Planning Application Ref: R/47/17/HH

Location: 3 Meadway, Rustington

Description of works: Demolition of existing garage and adding on new extension to side + roof extension to rear

Site Block Plan (1:500)

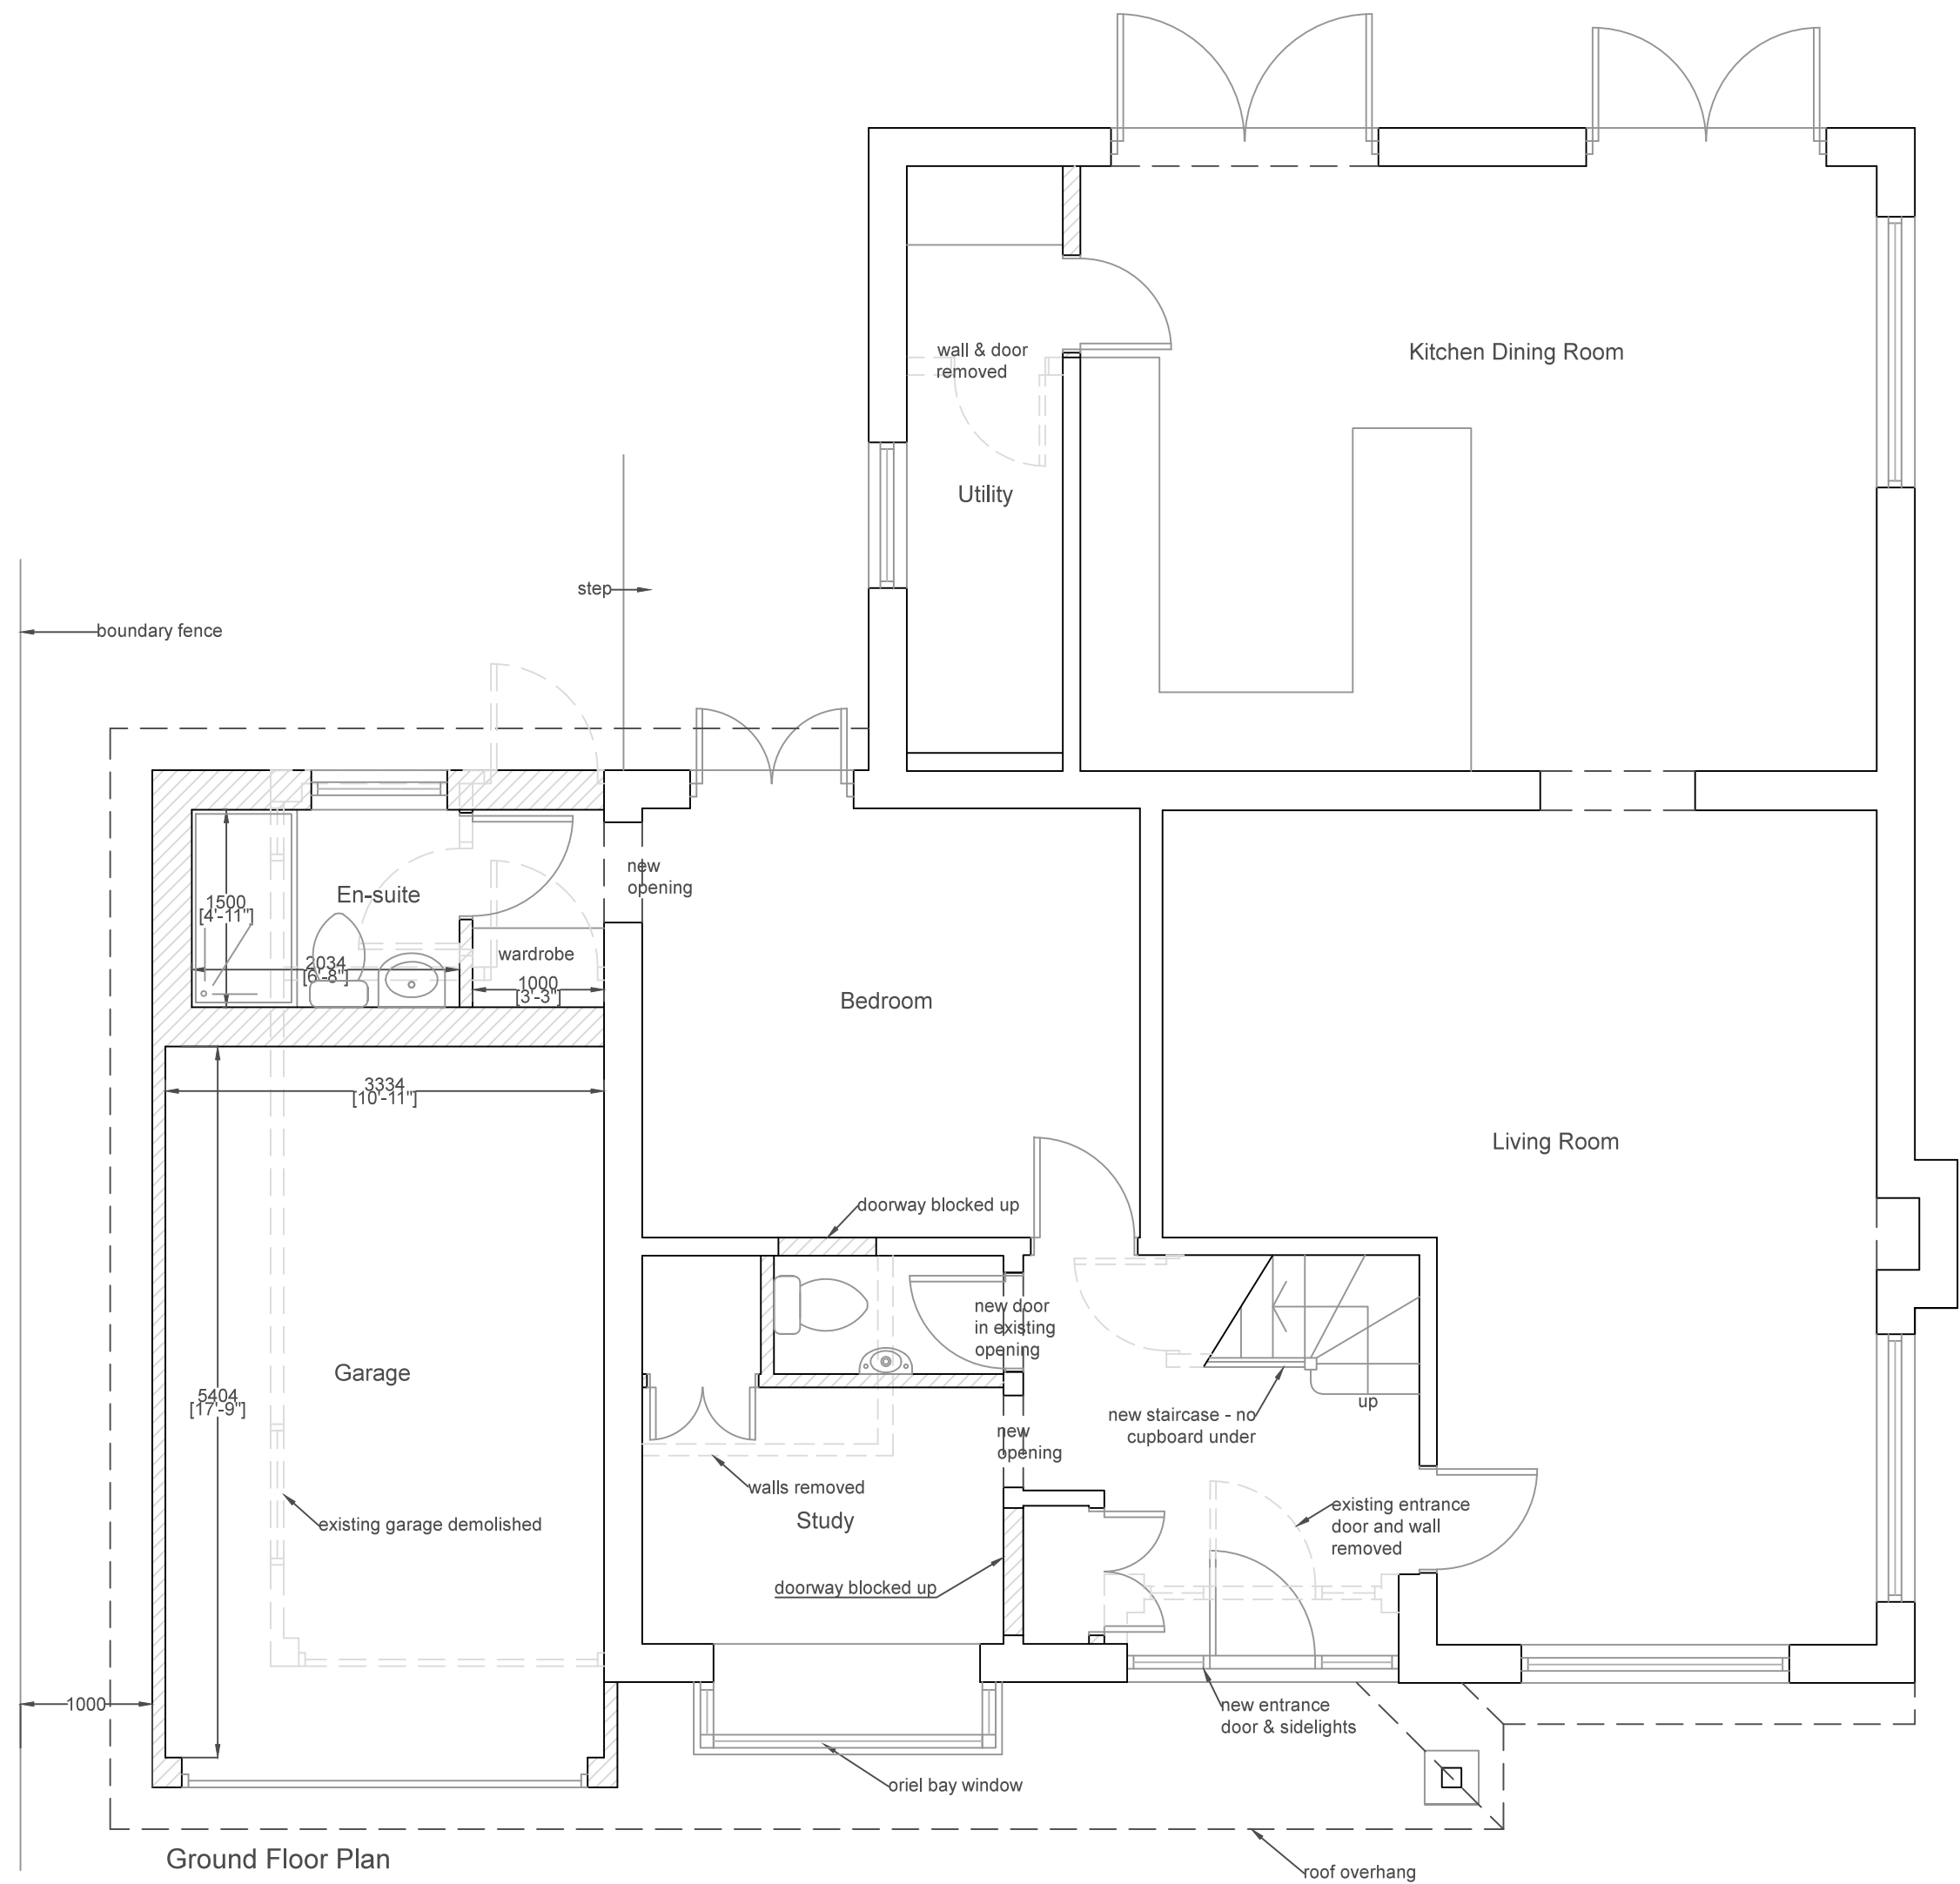
- There are no trees to the side or rear either on or off the property that might be affected by these proposals.
- However, there is a tree in the front garden that will need to be protected as materials could be stored here and concrete mixed in this zone – all of which would be harmful to the vigour and vitality of this tree.

- The applicants need to submit a **Tree Protection Plan** that details the specification for and location of protective fencing (see Figure 2 of BS5837) around the tree in the front garden to the extent of its canopy spread.
- A planning Condition will be needed on receipt of this plan which refers to full compliance with it during the construction process.
